A12 CHELMSFORD TO A120 WIDENING SCHEME

RELEVANT REPRESENTATION
ON BEHALF OF THE PARTNERS OF J A BUNTINGS AND SONS

- EXISTING CATCHMENT AREAS:**
- EXISTING CATCHMENT S3-OU16
  - EXISTING CATCHMENT S3-OU17
  - EXISTING CATCHMENT S3-OU18
- PROPOSED CATCHMENT AREAS:**
- PROPOSED CATCHMENT S3-OU16
  - PROPOSED CATCHMENT S3-OU17
  - PROPOSED CATCHMENT S3-OU18

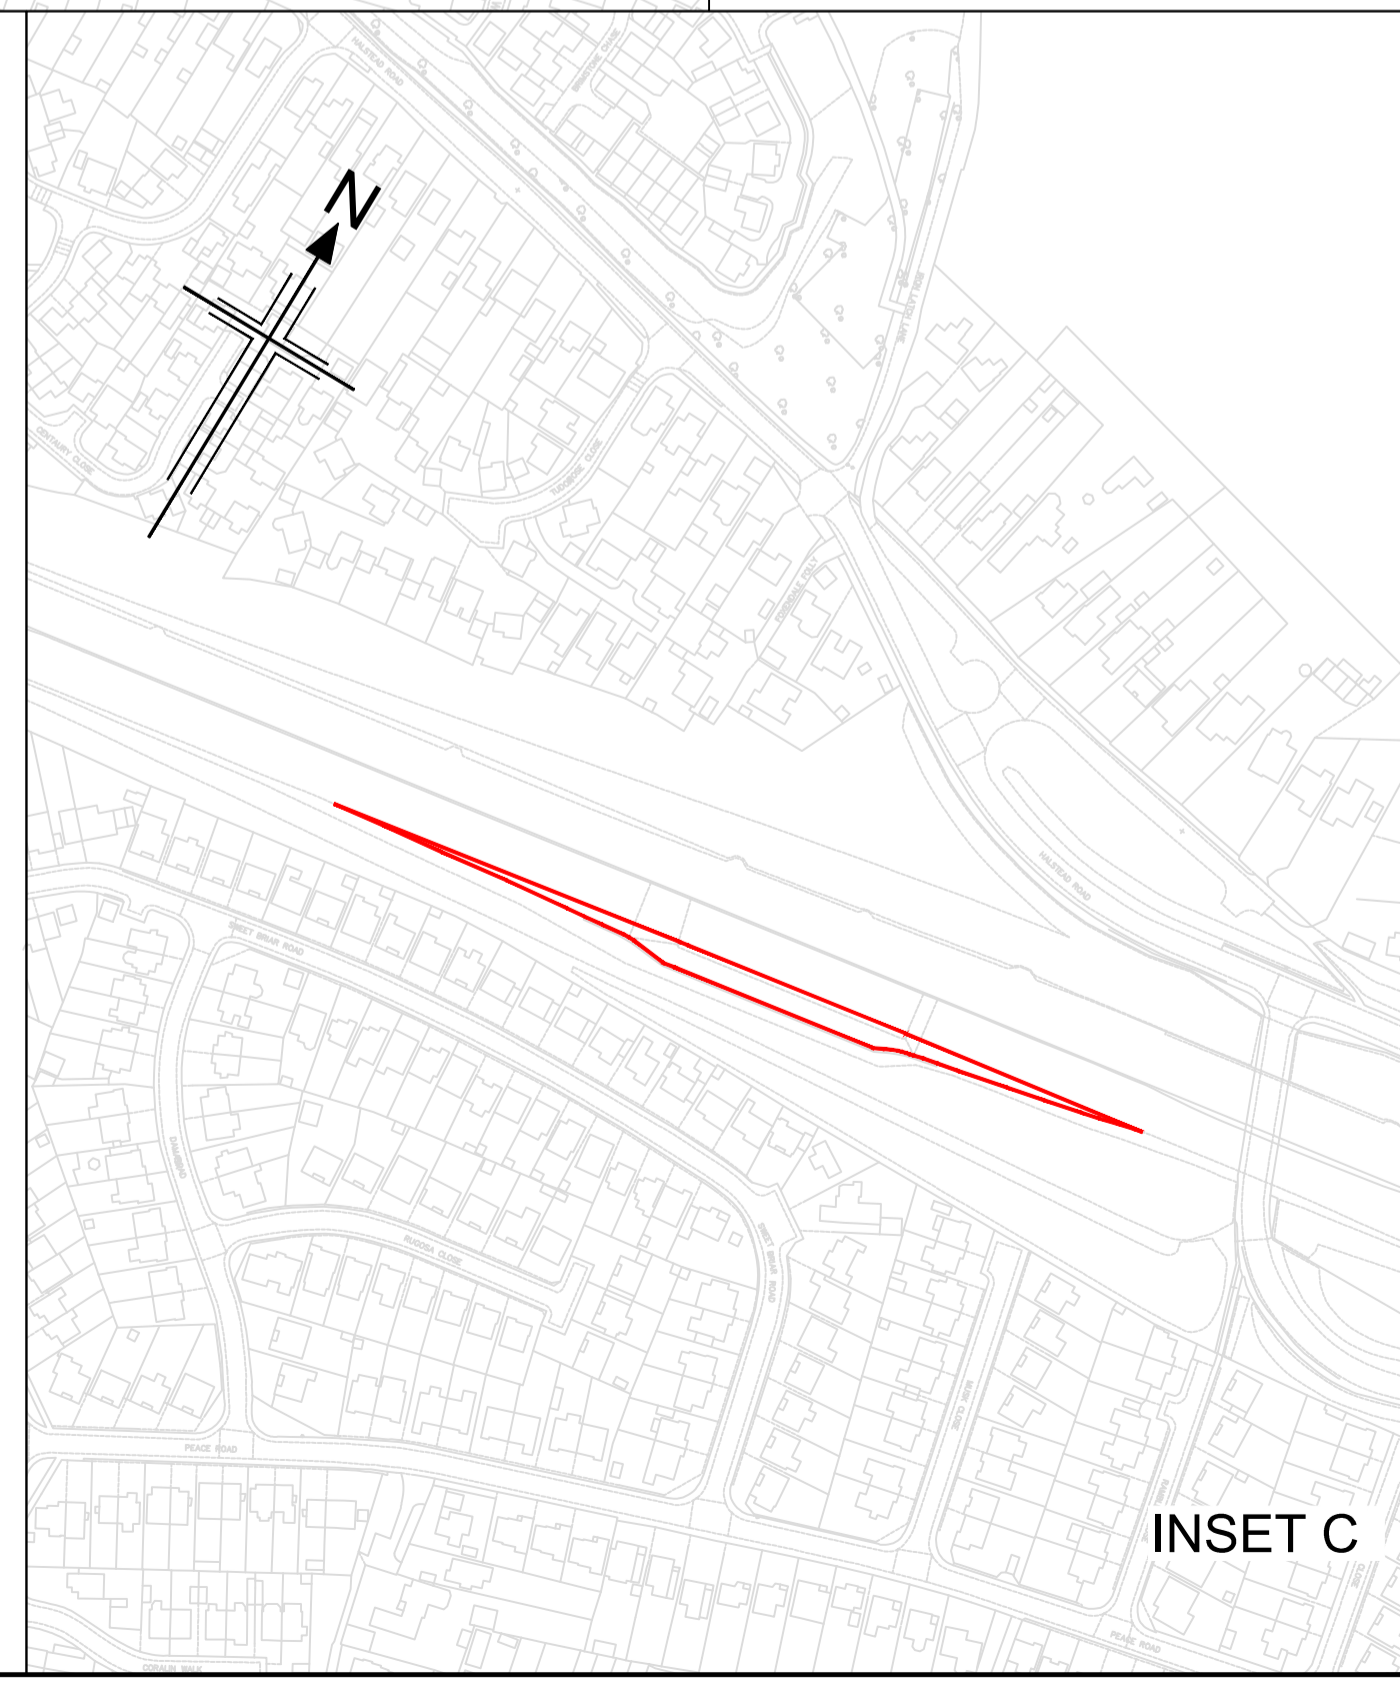
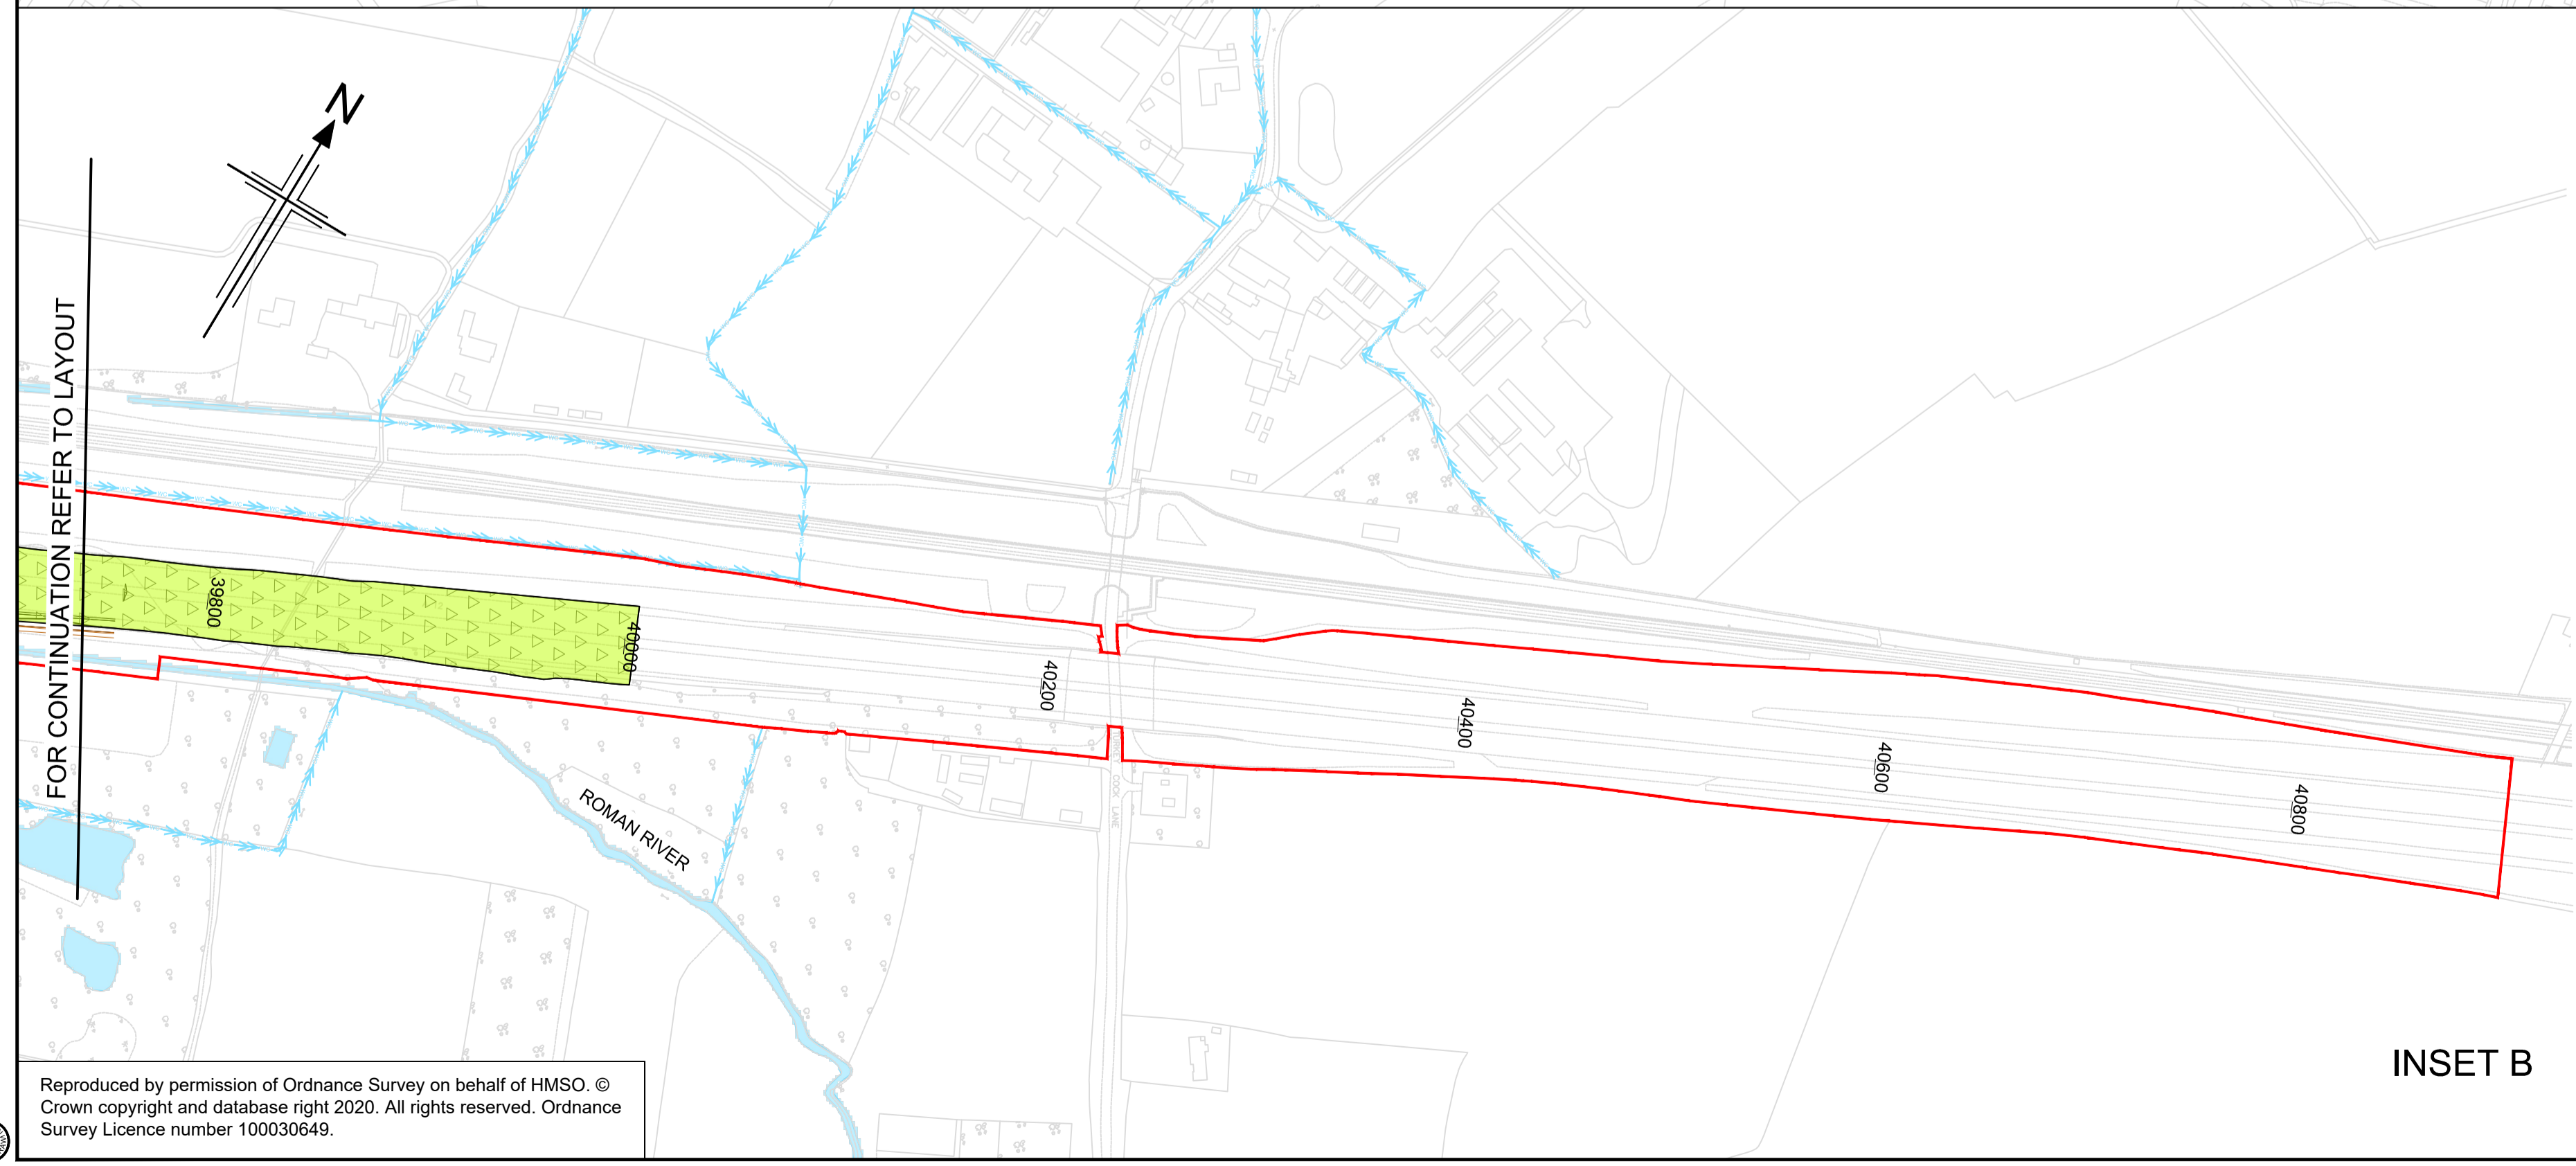
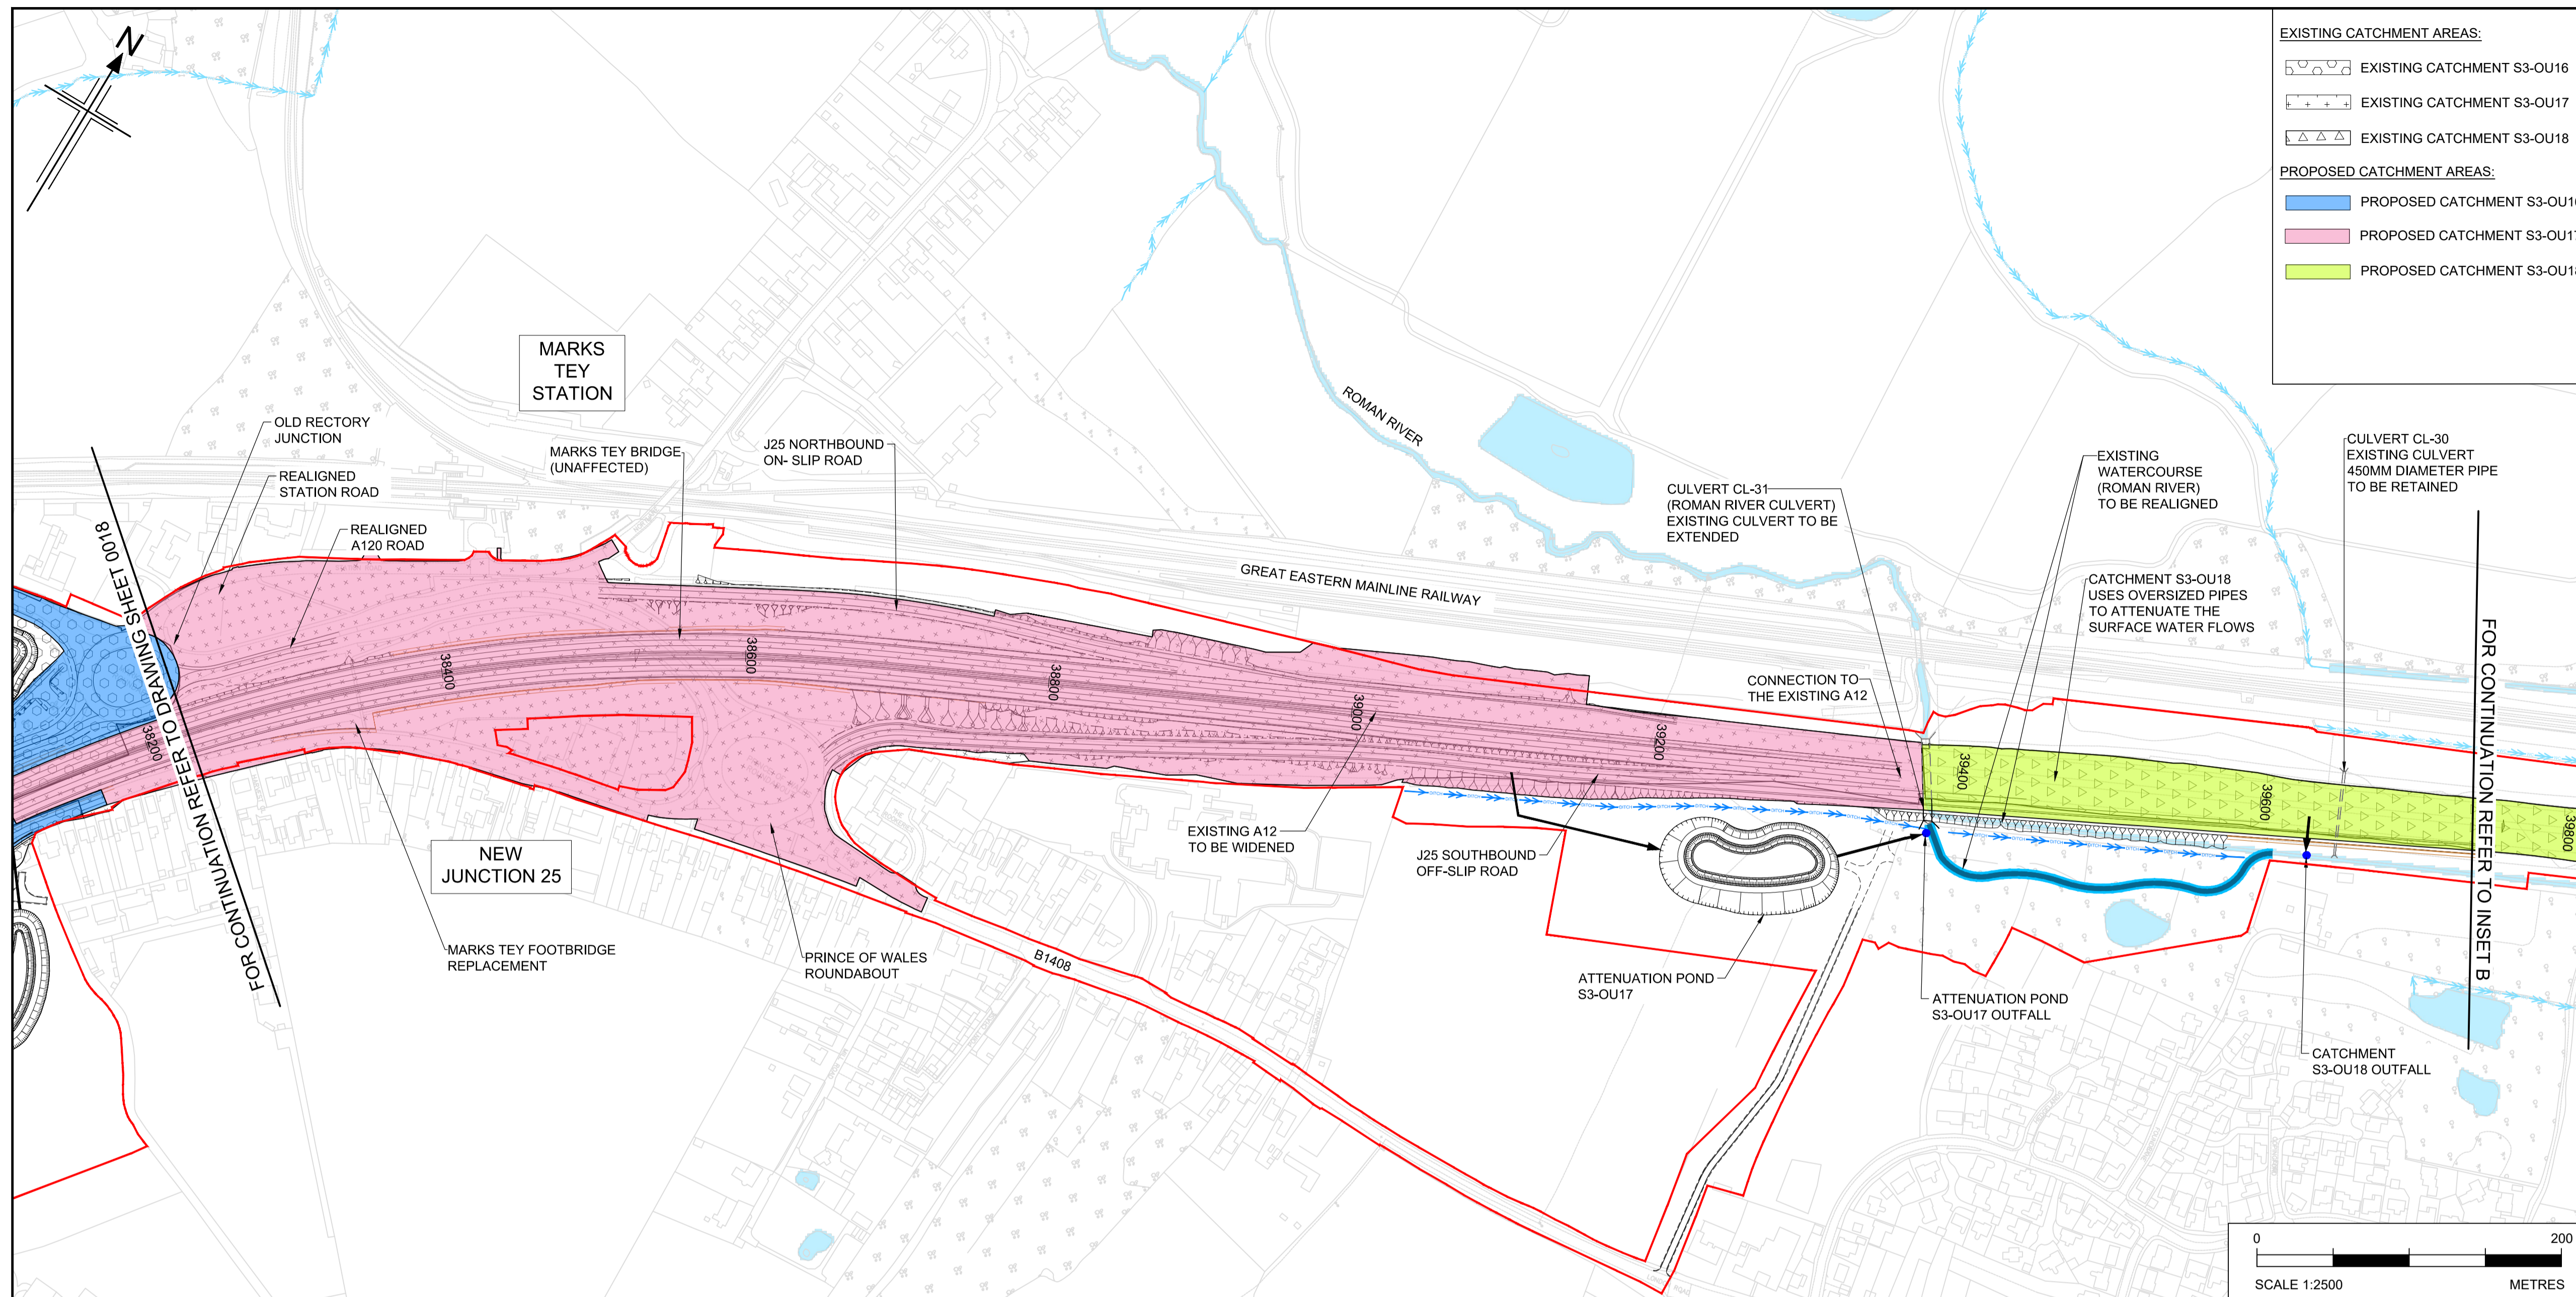
26. The Landowners object to the proposals for Attenuation Pond S3-OU7 & OU8A (Work No. 64) and Attenuation Pond S3-OU8 (Work No. 65(a)) due to the excessive land take and resulting impact on both the ability to reuse the land in question for agriculture and the deliverability of the Pigeon Scheme. The Landowners propose an alternative of combining the aforementioned attenuation ponds in the location of Attenuation Pond S3-OU7 & OU8A (Work No. 64). WSP have undertaken a review of the information presented as part of the Application and, based upon site topography, this has been assessed as a viable alternative. The combined basin minimises land take (combining basins reduces overall footprint due to the requirement for side slopes to the ponds) and will create a larger block of farmable land.

28. Attenuation Pond OU14 (Work No. 77) is located between Water Course 21 and Water Course 21a just south of the A12. The Landowners object to the proposals for Attenuation Pond OU14 due to the excessive land take and resulting impact on both the ability to reuse the land in question for agriculture and the deliverability of the Pigeon Scheme.

29. WSP's analysis proposes that Attenuation Pond OU14 should be located closer to the road and that the design should be narrower and more linear. This would allow the maintenance track to move closer to the overbridge and reduces the land take for drainage attenuation purposes. The discharge rate and outfall location would not be affected by this modification. However, by reducing land take the proposed modification would reduce the impact of the A12 Scheme upon the Landowners' ability to re-use the land in question for agricultural purposes and upon the Pigeon Scheme following completion of construction of the A12 Scheme.
